**Consultation Response from KC,
Highways Development Management**

2025/90082 Land adj, Gernhill Avenue, Fixby, Huddersfield, HD2 2GT

Formation of agricultural / forestry track

Date Responded: 27/03/2025.

Land Adjoining Gernhill Avenue Site Plan

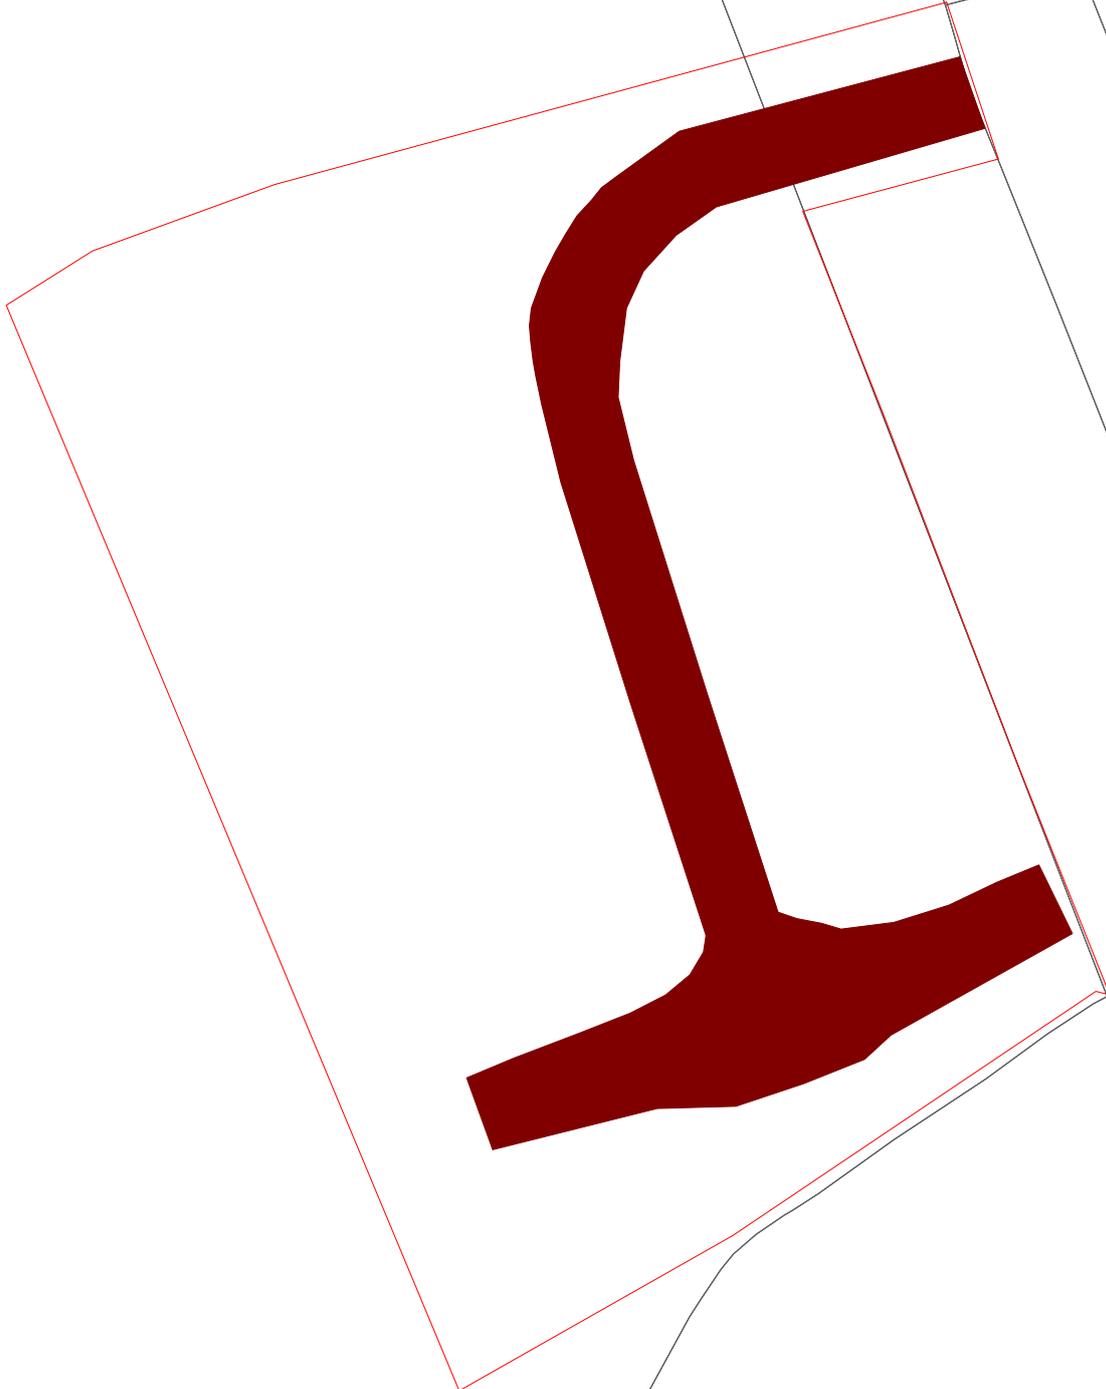
A new vehicle access is proposed onto Gernhill Avenue which will require the widening of the existing dropped kerb.

No information has been provided on how the track will be constructed.

The highway works required to provide the new access, will also need to be constructed under the section 184 agreement of the 1980 Highways Act (vehicle crossings over footways and verges). You are required to consult the Design Engineer (Kirklees Street Scene: 01484 221000) with regard to obtaining this permission and approval of the construction specification. Interference with the highway without such permission is an offence which could lead to prosecution.

The applicant is advised to contact the Kirklees Street scene team as soon as possible to determine the exact extent of the works required.
